MODIFICATION REQUEST:
Block 2; 'One Central Park'
26 Broadway, Chippendale
(Former Carlton & United Breweries Site)

Modification MP09_0078 MOD 3

Director-General's
Environmental Assessment Report
Section 75W of the
Environmental Planning and Assessment Act 1979

PLAN SHOWING GFA OF
LEVELS 32 & 33 AT
"ONE CENTRAL PARK"
BROADWAY

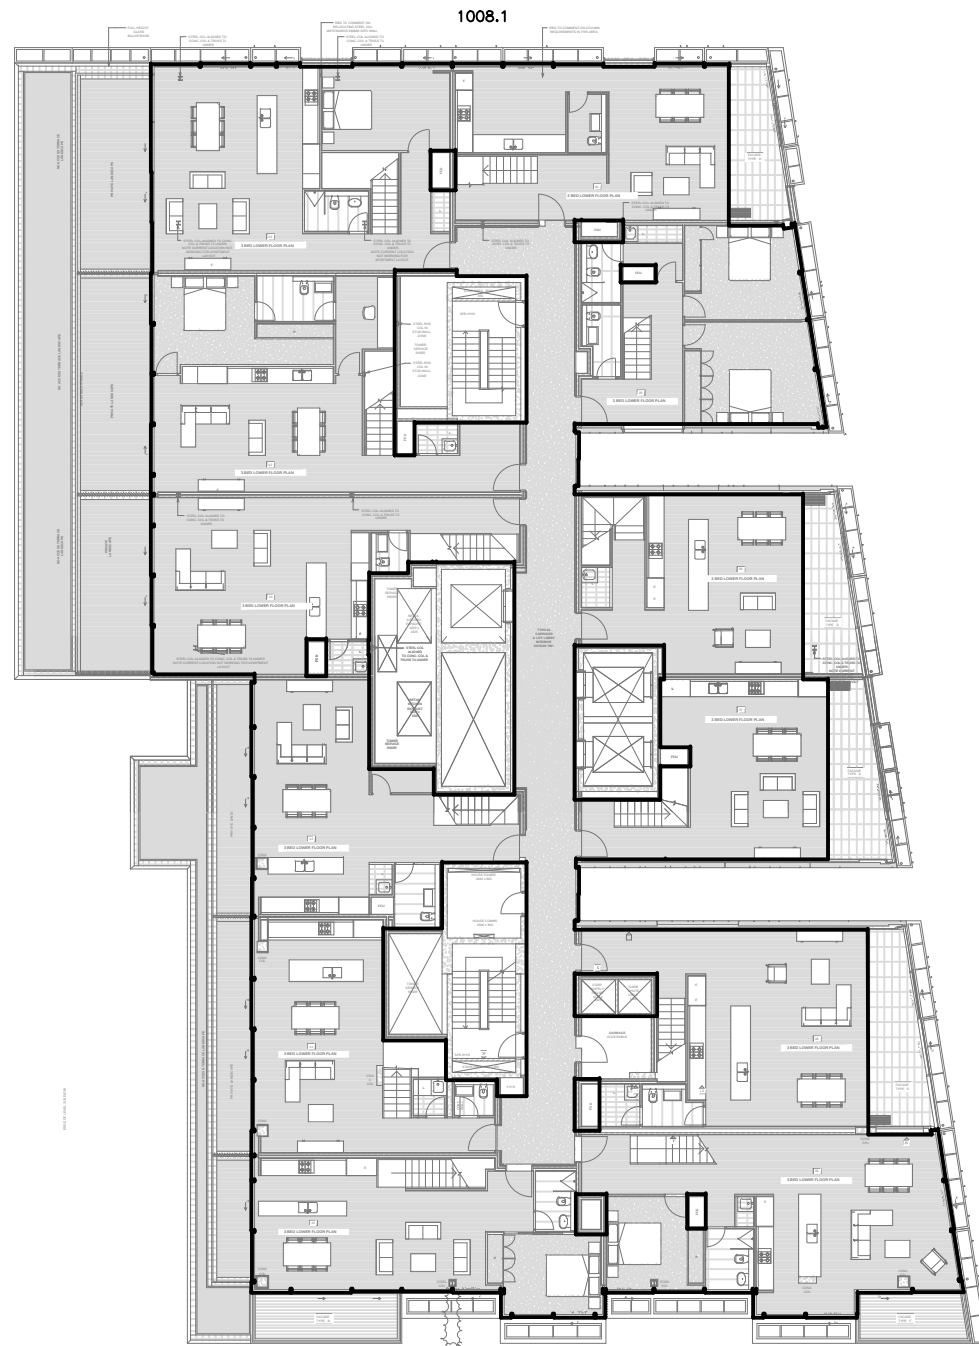
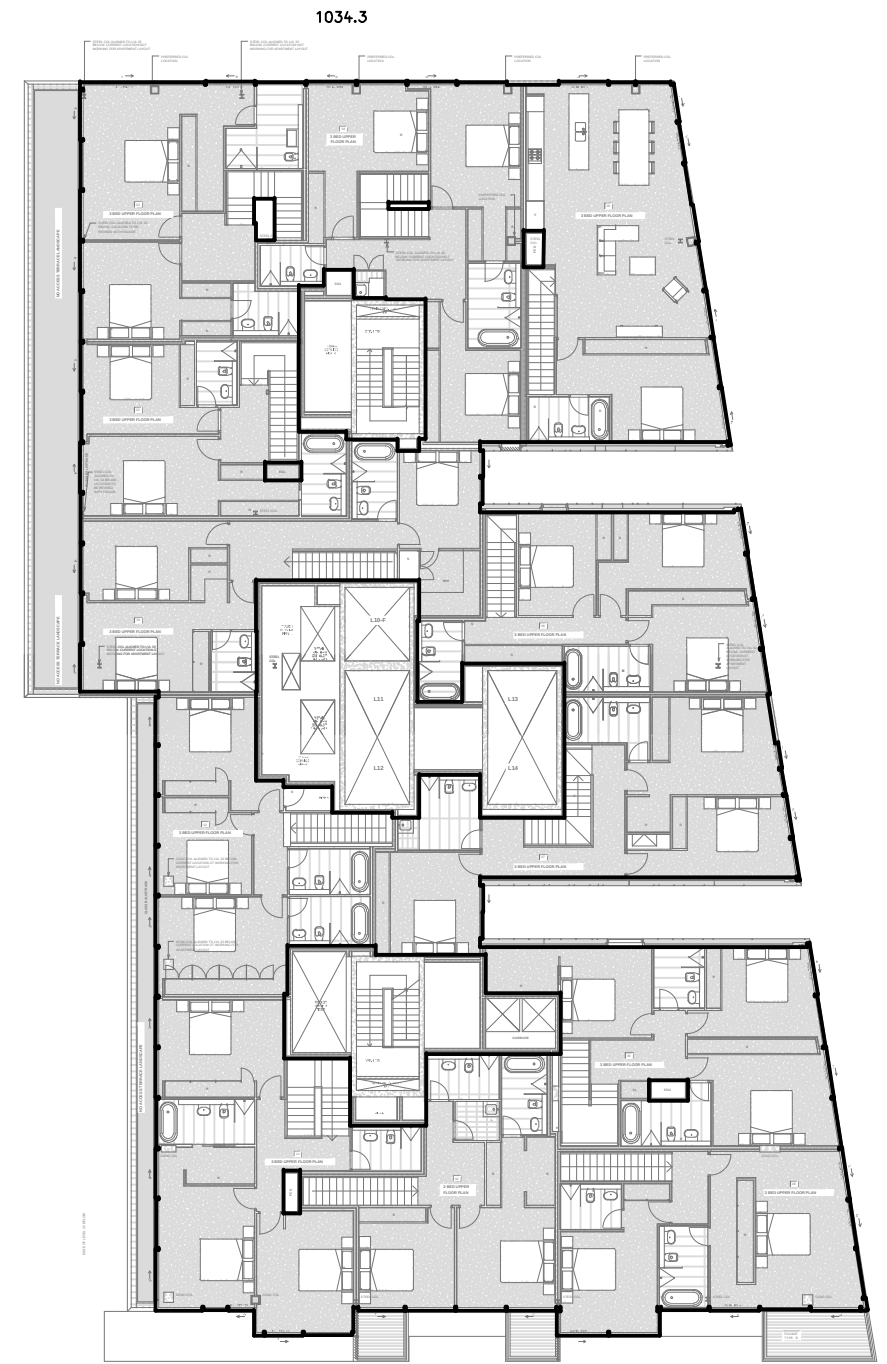
The proposal will result in some modifications to the approved residential apartments on levels 29-33 of the East Tower (detailed in **Table 1** above). The proposed changes are minor and will not impact upon the number of apartments. The minor changes to apartment layouts will not have any detrimental impacts on the residential amenity afforded to future residents. The proposed modifications to the apartment layouts are therefore considered acceptable.

PLAN SHOWING GFA OF
LEVEL 16 AT
"ONE CENTRAL PARK"
BROADWAY

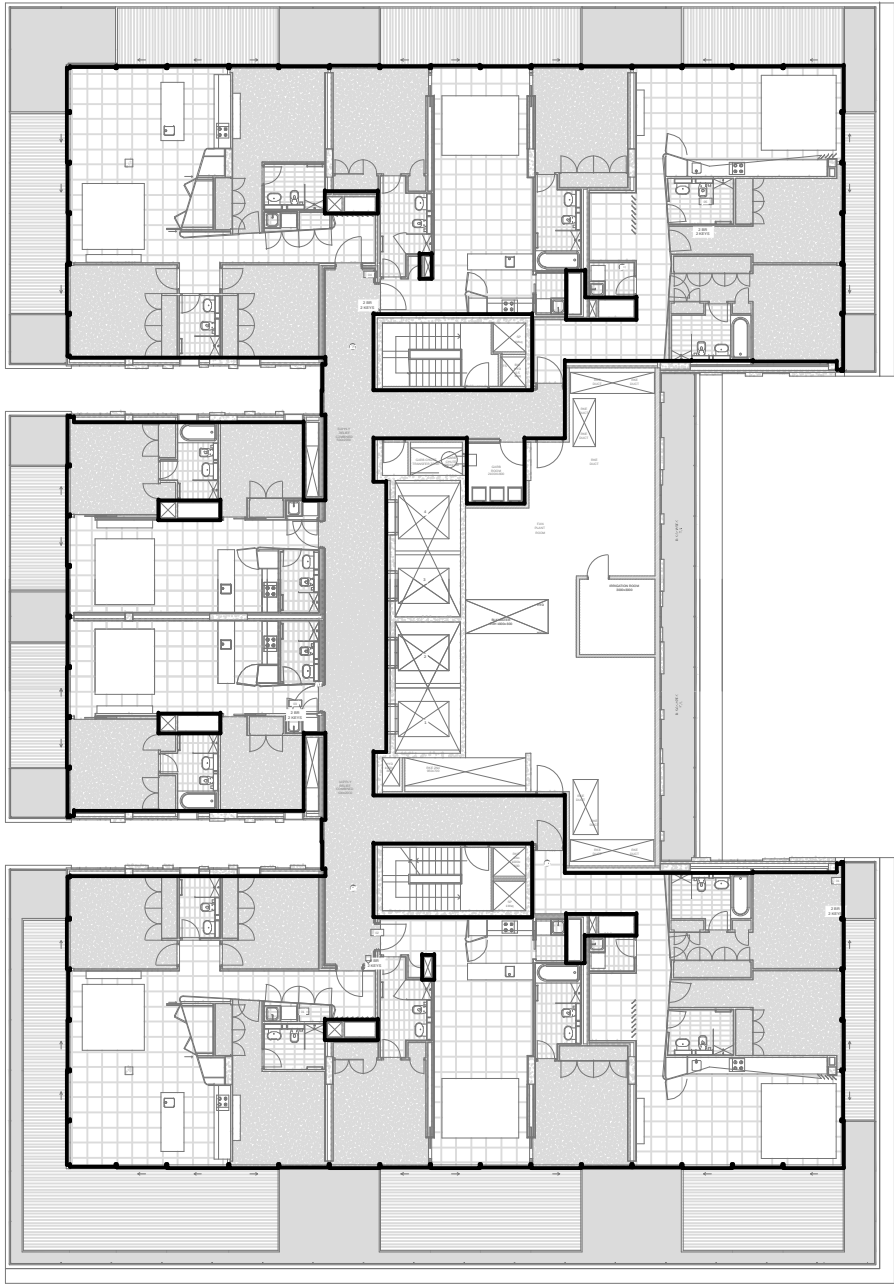
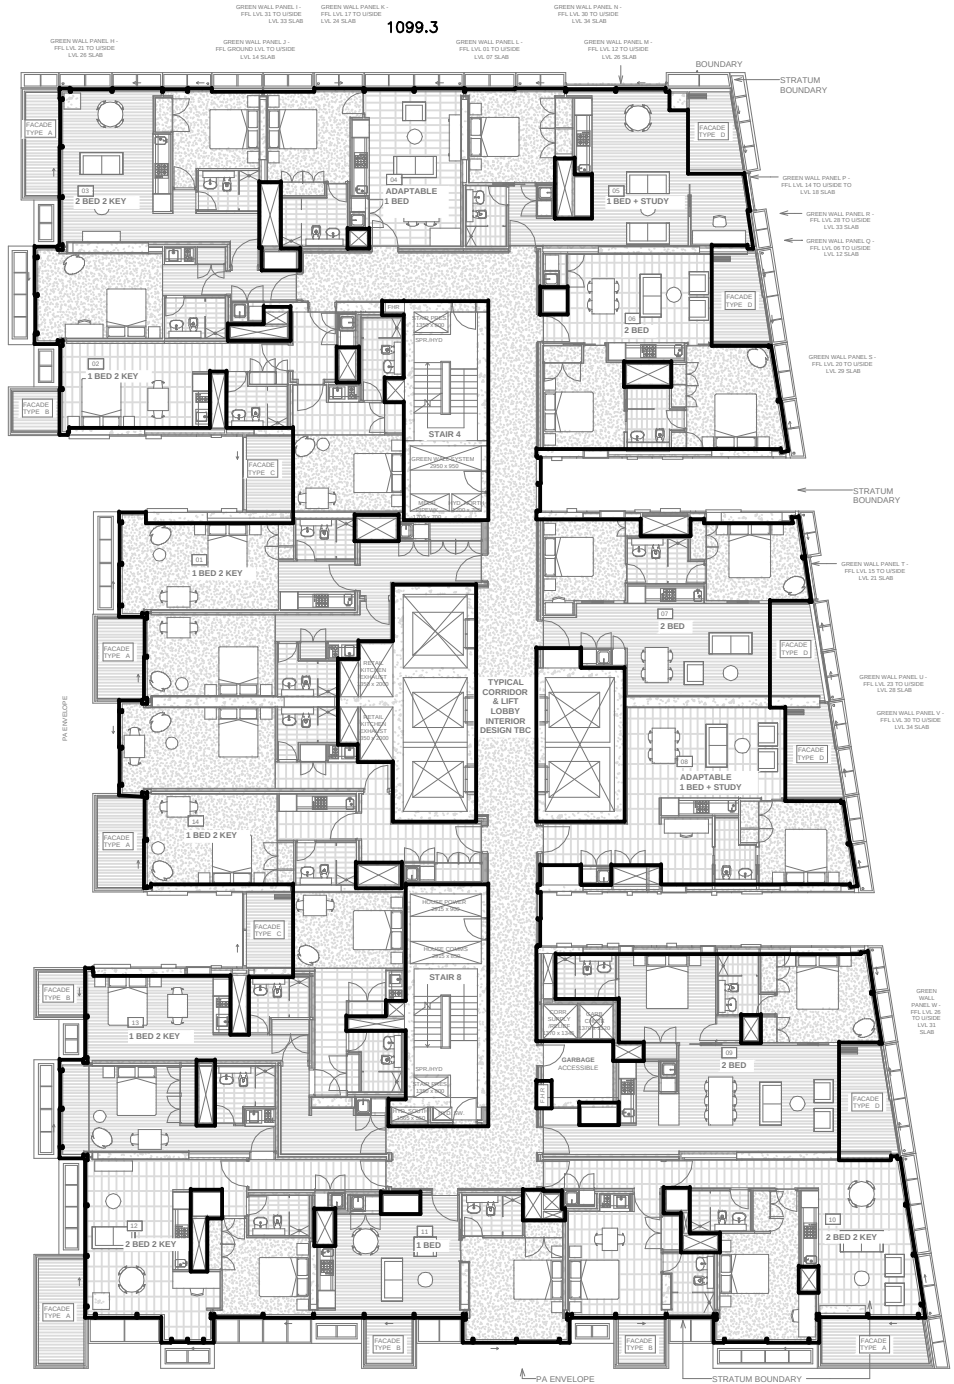
West Tower	<ul style="list-style-type: none">• increase in building height to accommodate modified building management apartment at roof level; and• modified terrace area and landscaping to apartments on level 16.
